# Rezoning Transportation Analysis

Petition Number: 2023-012

**From:** Jake Carpenter, PE  
Jacob.carpenter@charlottenc.gov  
980-221-5675

Date	Description
5-24-23	First Review (PDM)

REZONING
SITE PLAN

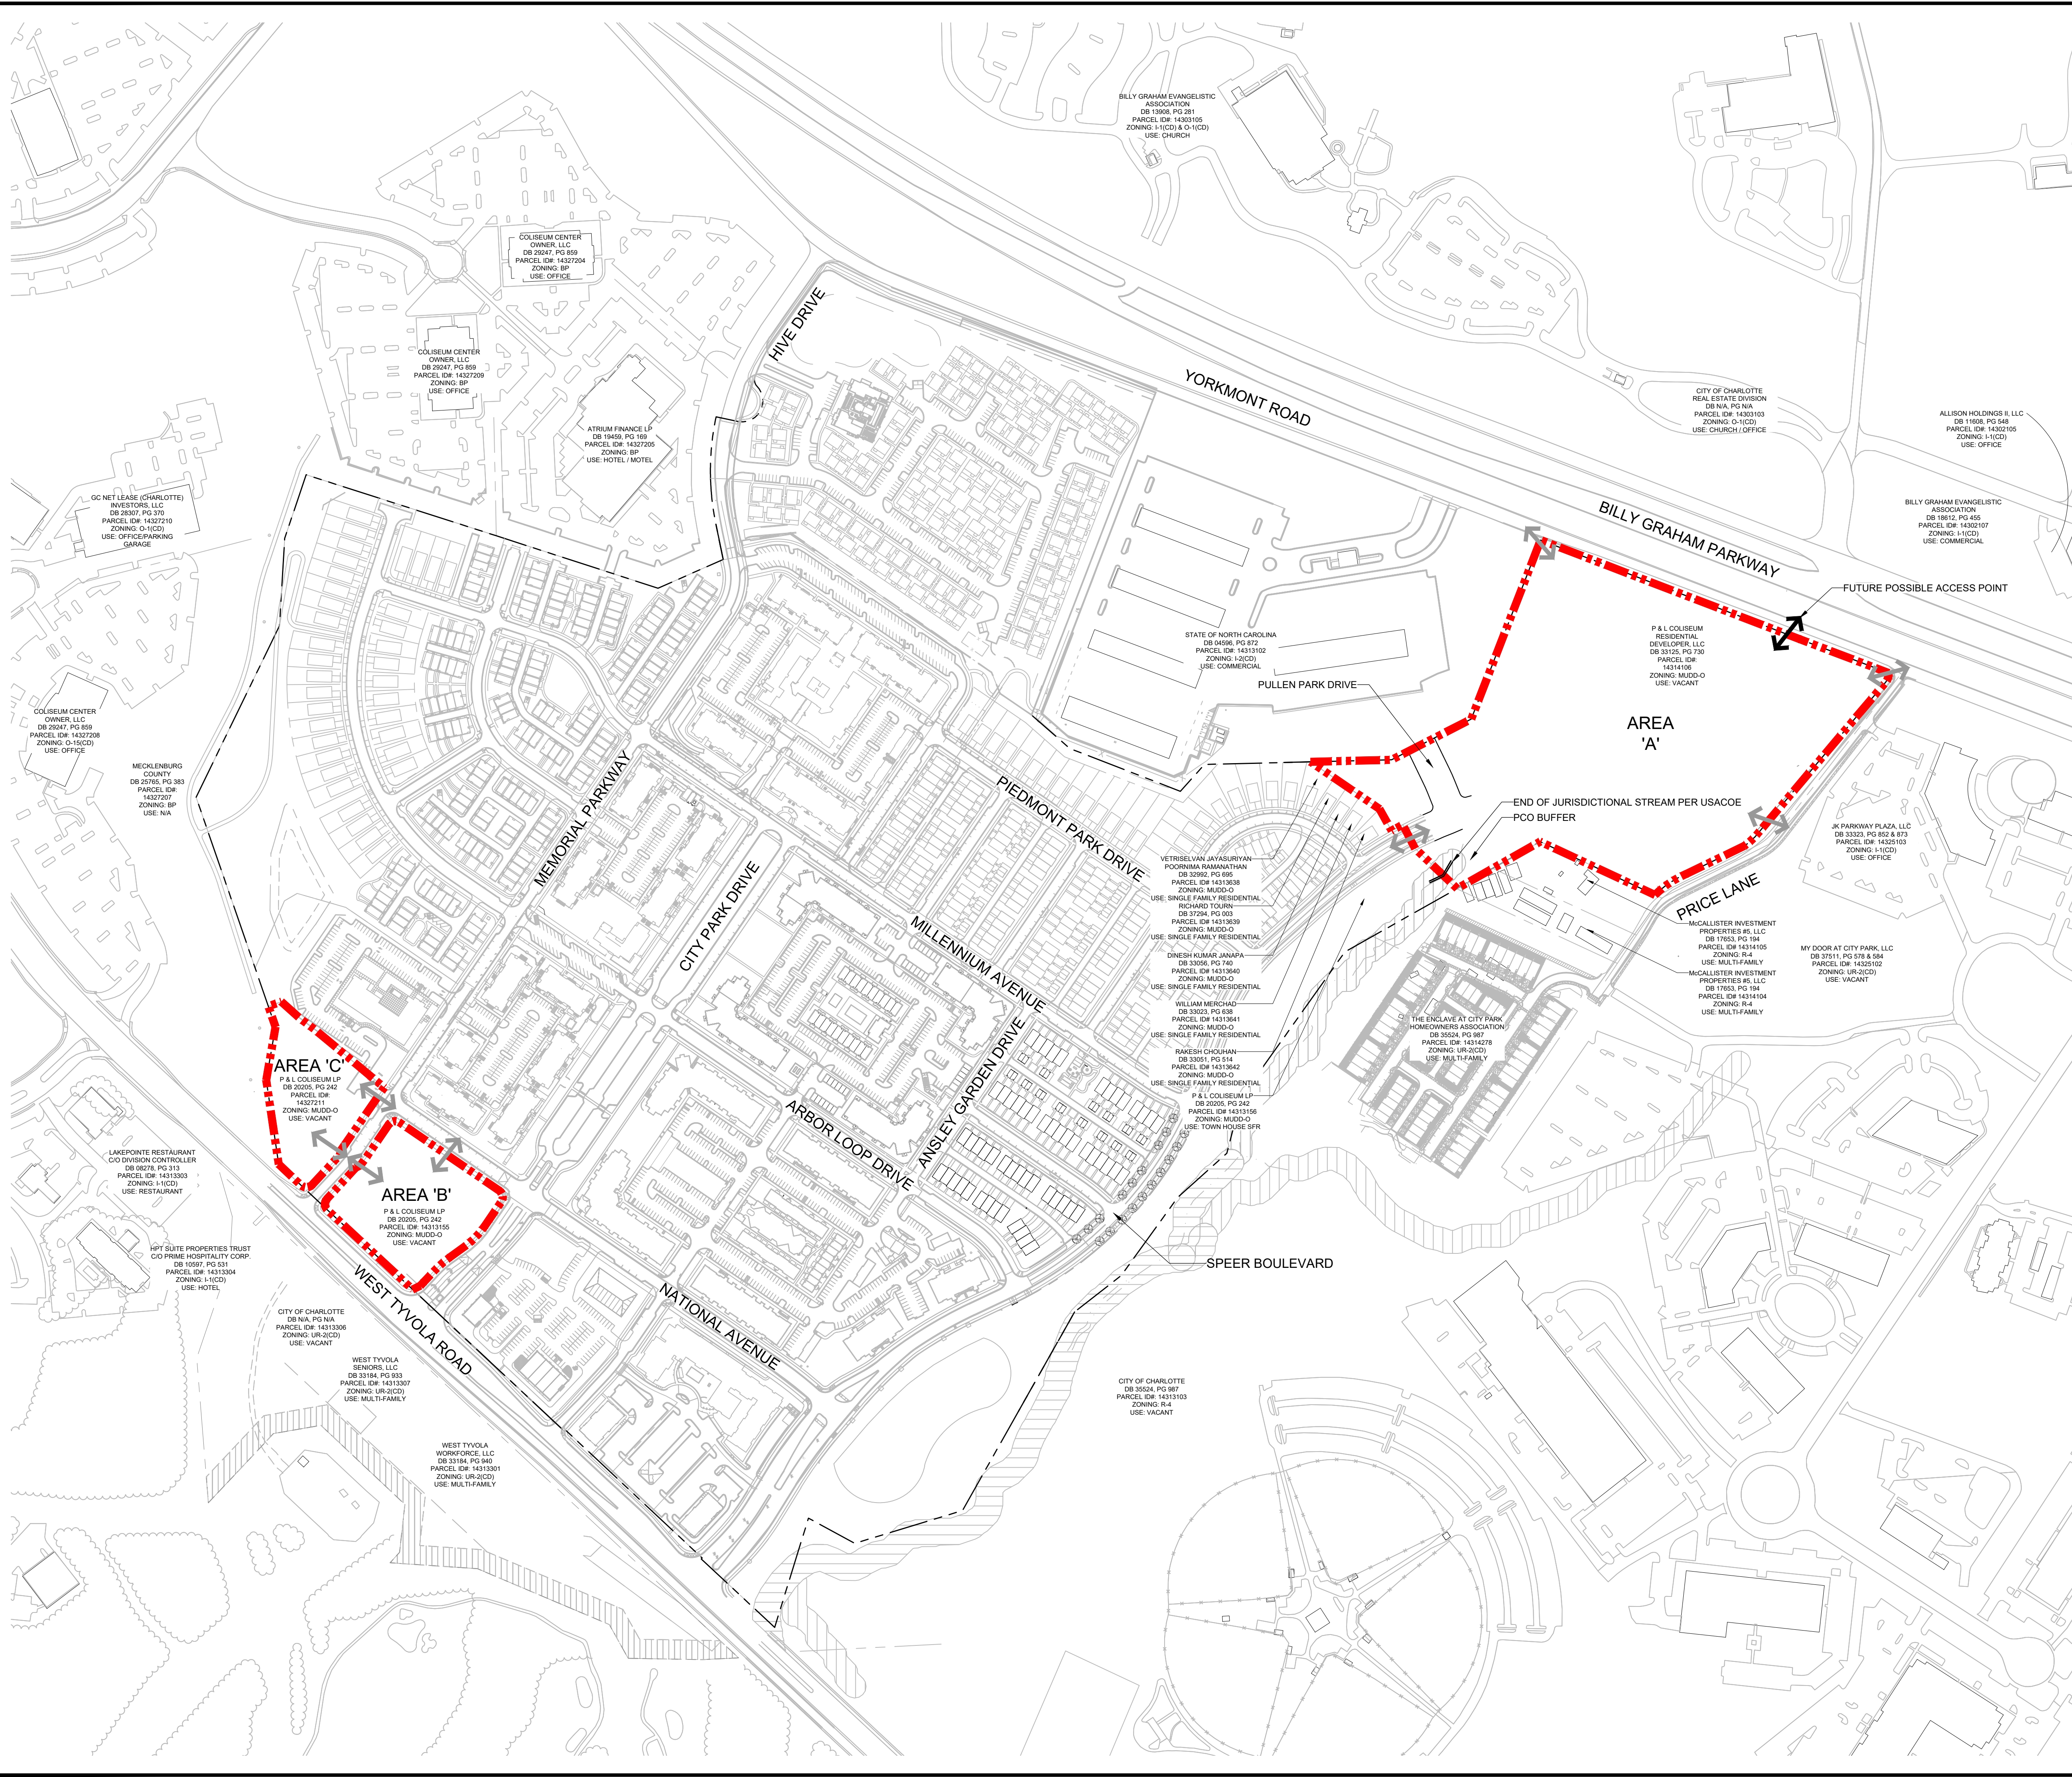
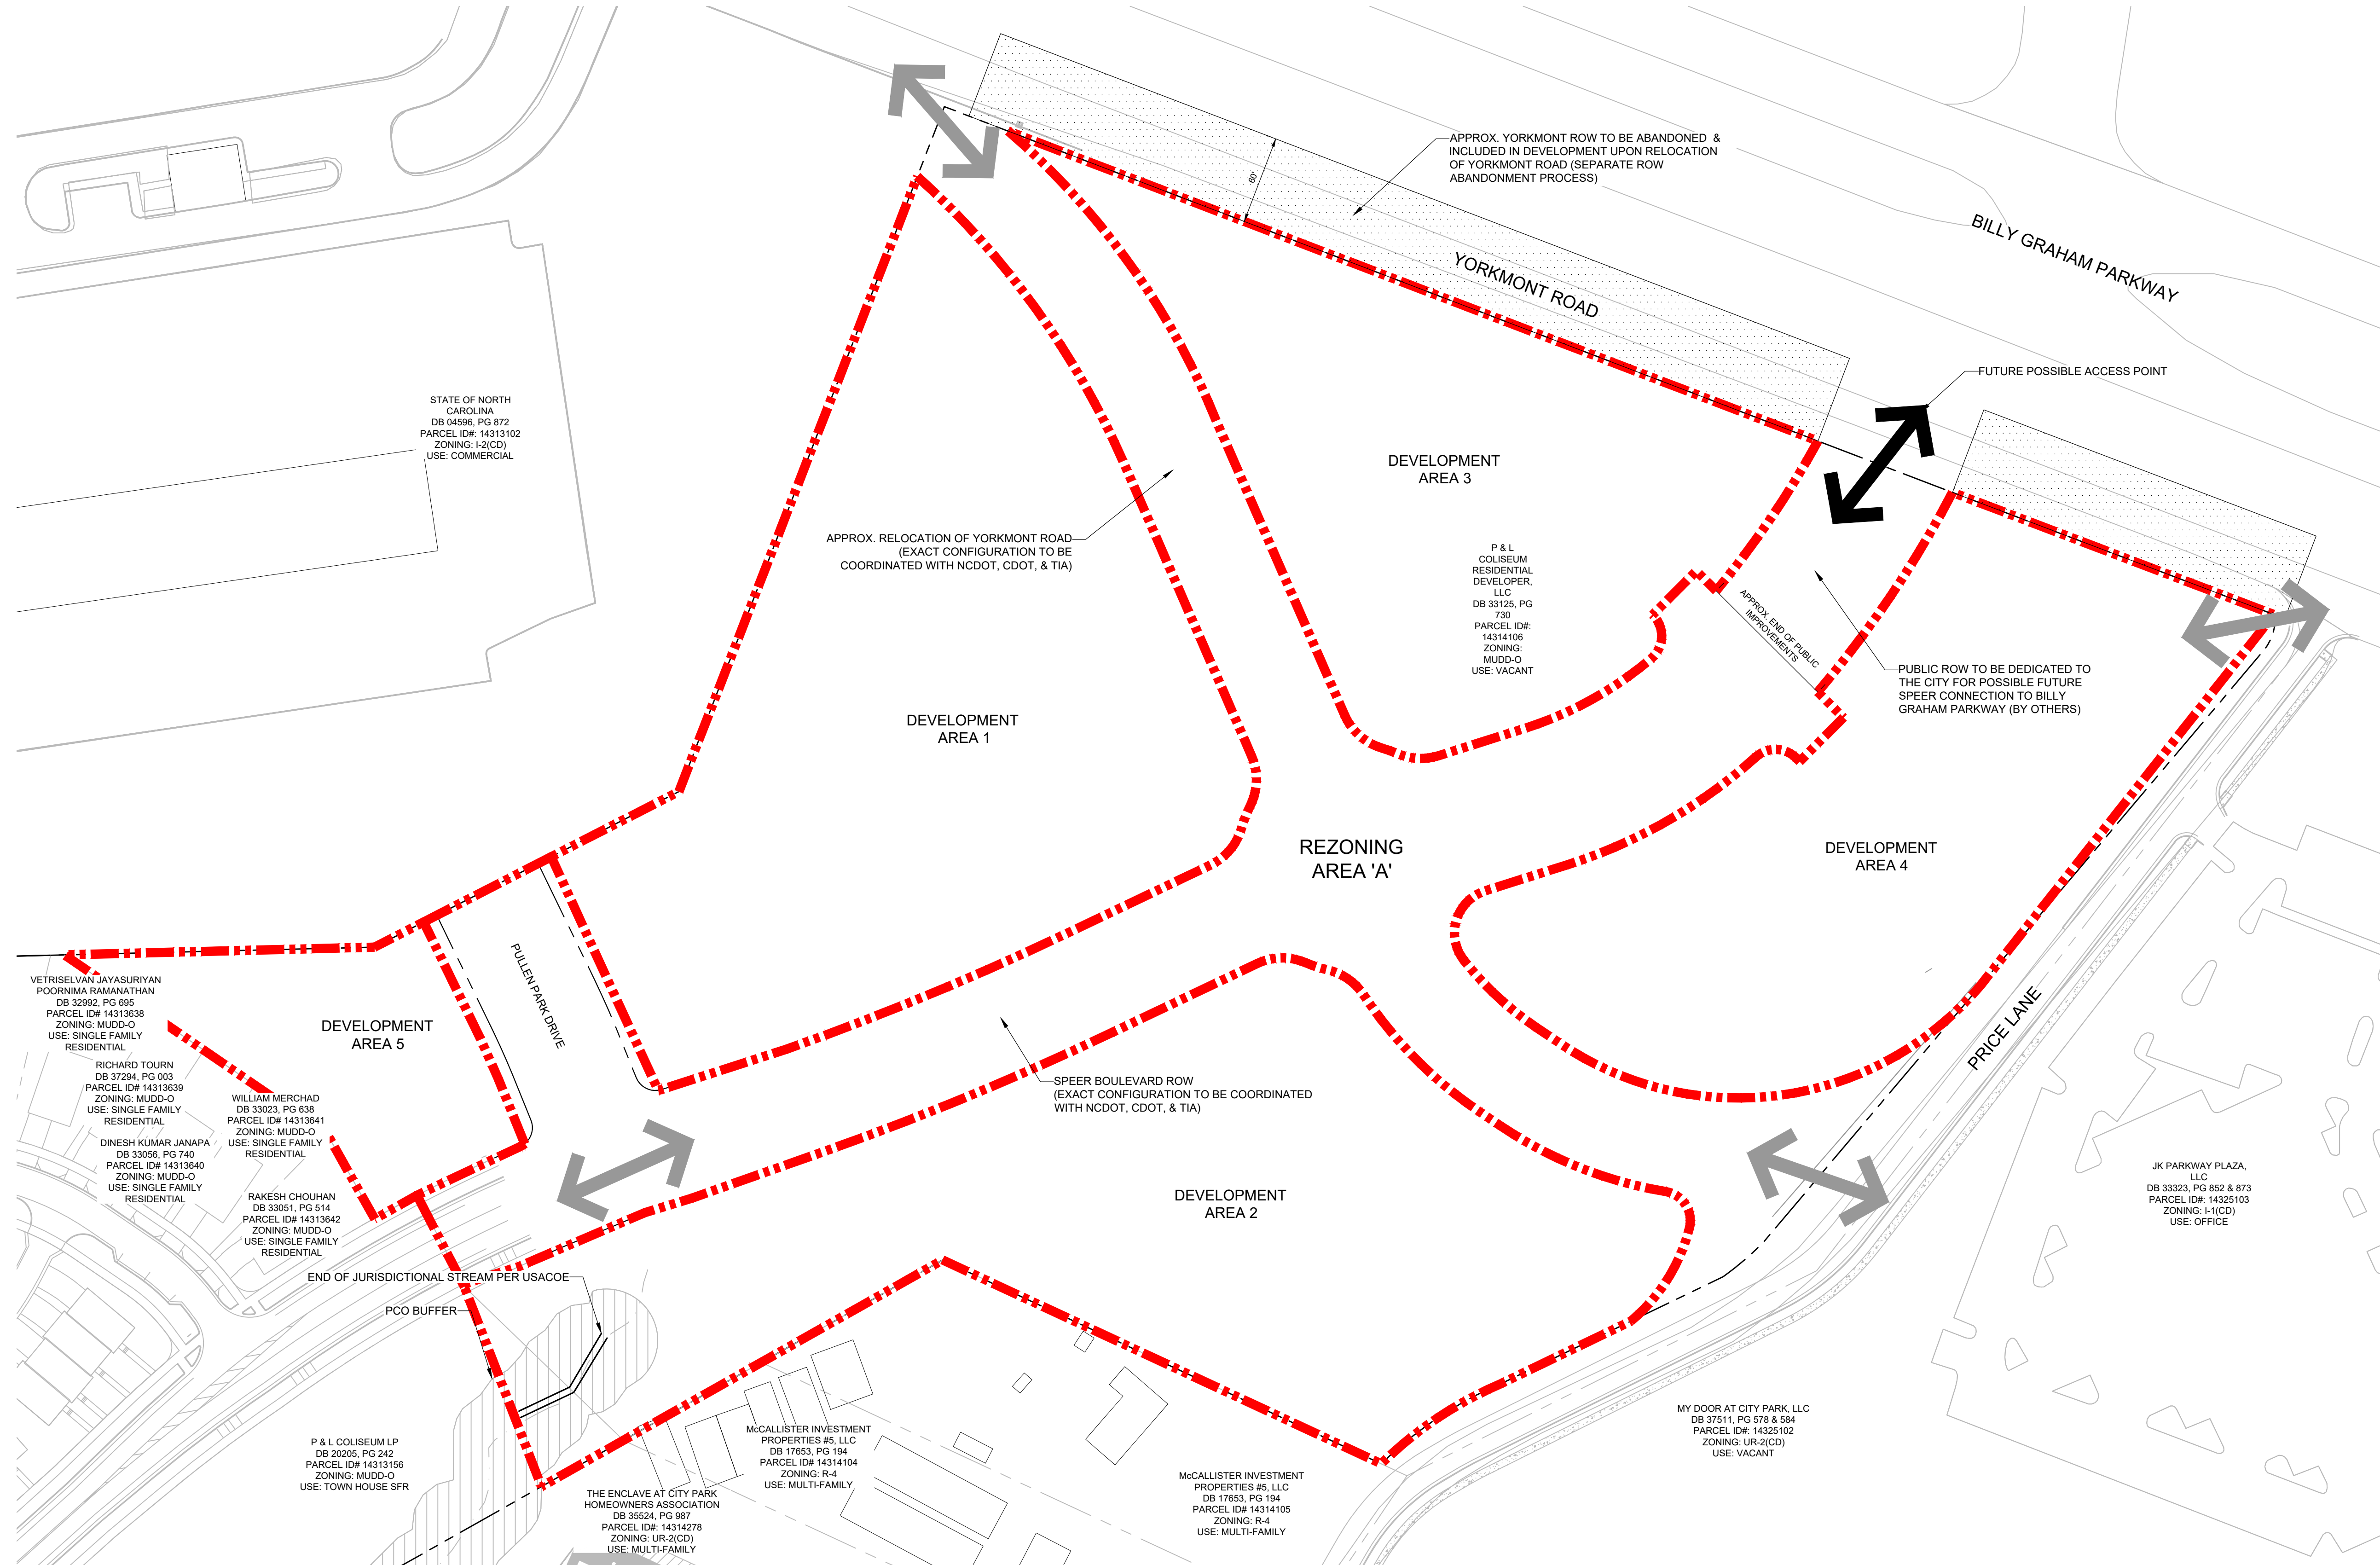
- a. **Speer Boulevard (Shopton Rd Extension):** Location of curb and gutter to be installed 18.5 feet from roadway centerline to the back of curb to accommodate the Charlotte Streets Map with a roadway typical section of a 2 avenue with bike lanes, 8-foot sidewalk and 8-foot planting strip.

- b. **Yorkmont Road:** Location of curb and gutter to be installed 24 feet from roadway centerline to the back of curb to accommodate the Charlotte Streets Map with a roadway typical section of a 2+ avenue with bike lanes, 8-foot sidewalk and 8-foot planting strip.

Label and dimension the curb and gutter from the centerline for each road on the site plan.

3. Revise site plan and conditional note(s) to commit to dedicate a minimum of 35 feet of right-of-way from the road centerline on Yorkmont Road and Speer Boulevard. The site plan shall label and dimension the right-of-way from the road centerline.

4. Revise site plan and conditional note(s) to commit to provide an 8-foot planting strip, and 8-foot sidewalk along Yorkmont Road and Speer Boulevard per the Charlotte Streets Map.

5. Revise site plan and conditional note(s) to commit to construct bicycle facilities by locating the curb and gutter 18.5' on Speer Boulevard and 24' on Yorkmont Road from the center line/installing a bike lane to meet the Council-adopted Charlotte BIKES Policy.

7. Revise site plan and conditional note(s) to commit to making the roadway connection from Speer Boulevard to Billy Graham Parkway including improvements to Billy Graham to make the connection
